New Wee Waa High School (SSD-21854025)
Request for additional information

I refer to the assessment for the New Wee Waa High School (SSD-21854025). The Department of Planning and Environment (Department) has reviewed the Submissions Report received on 31 March 2022 and referred it to Narrabri Shire Council (Council), Transport for NSW (TfNSW) and the Department's Biodiversity, Conservation and Science (BCS) Directorate. The Submissions Report has failed to adequately address a number of key issues as detailed in Council's, TfNSW and BCS' comments on the Submissions Report (**Attachment 2**).

Attachment 1 – Key issues

FIGURE 6 - STORMWATER CHANNEL LOCATIONS

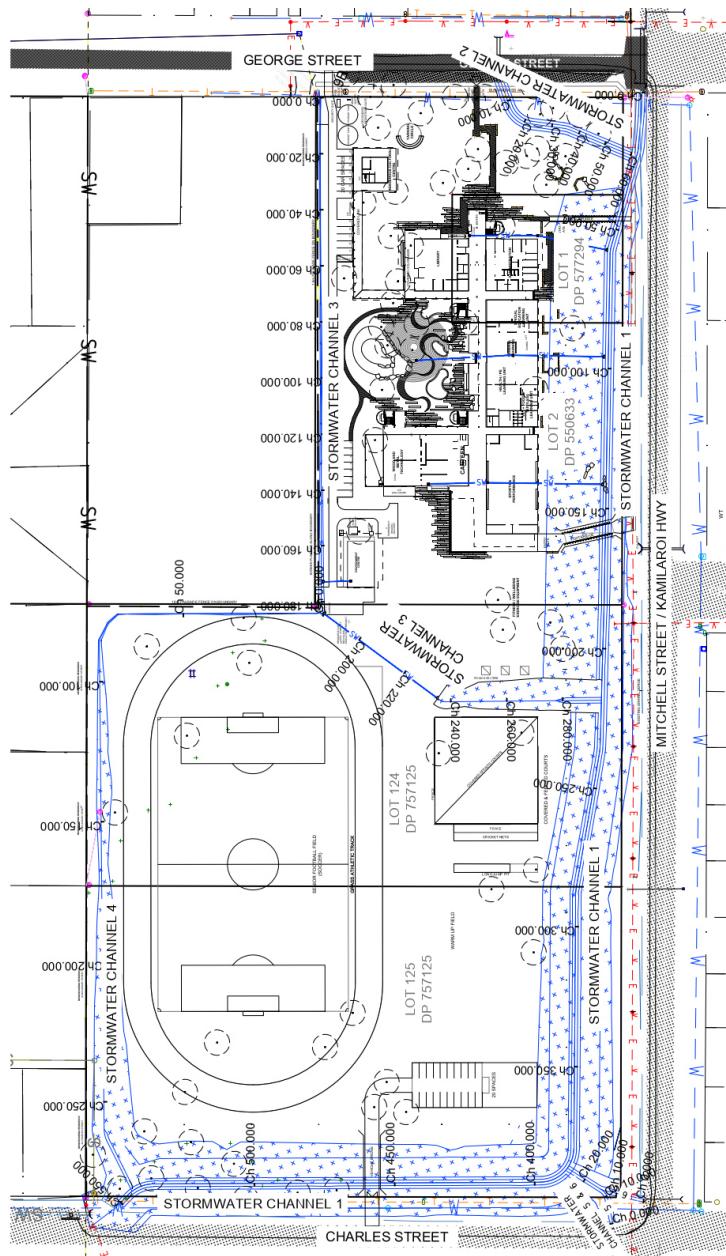
- b) Clarify whether the stormwater channel north and east of sports field forms part of the Part 5 works or is part of this SSD application. Civil plans indicate it forms part of the Part 5 works, however the architectural plans show it as part of the SSD application and the Submissions Report has not included a statement about this channel in Section 3.1.10.

TREES TO BE REMOVED

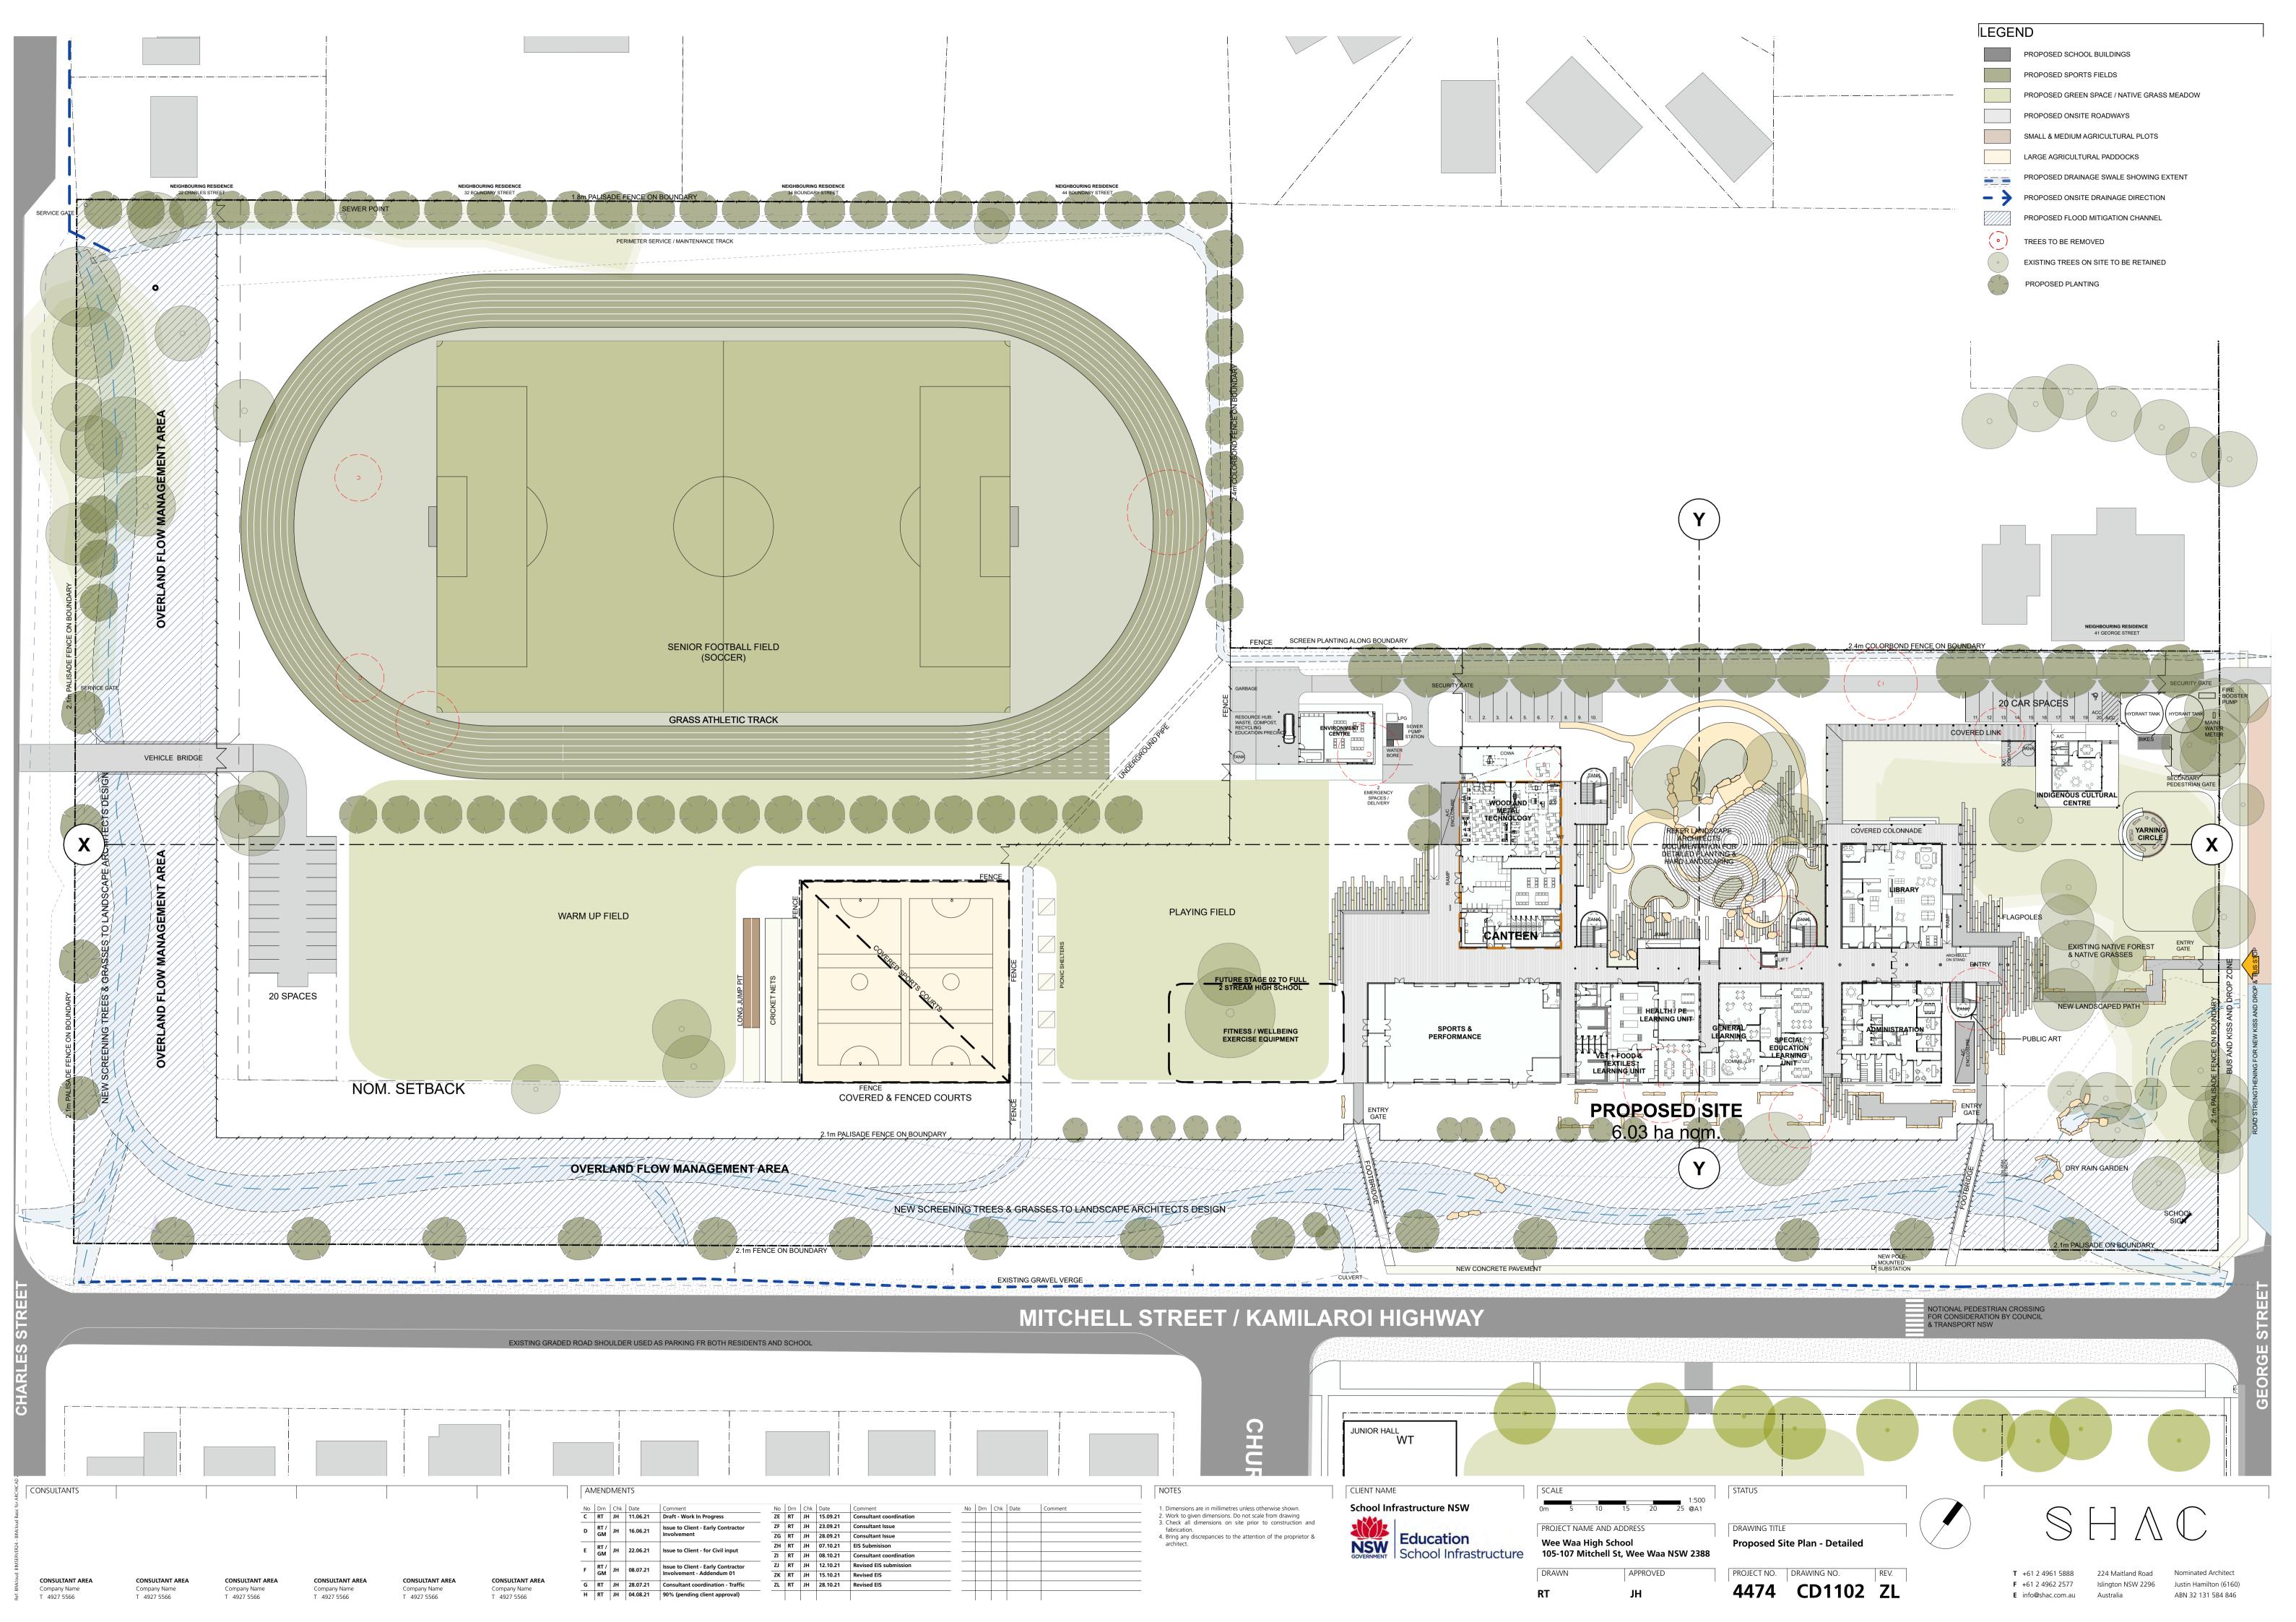
- ii. Architectural drawing CD1102 ZP and WD1104 F
 - iii. Architectural drawing WD 1104 F identified trees within the sports field and play courts to be removed under a separate approval. This is inconsistent with other plans which indicates tree removal.
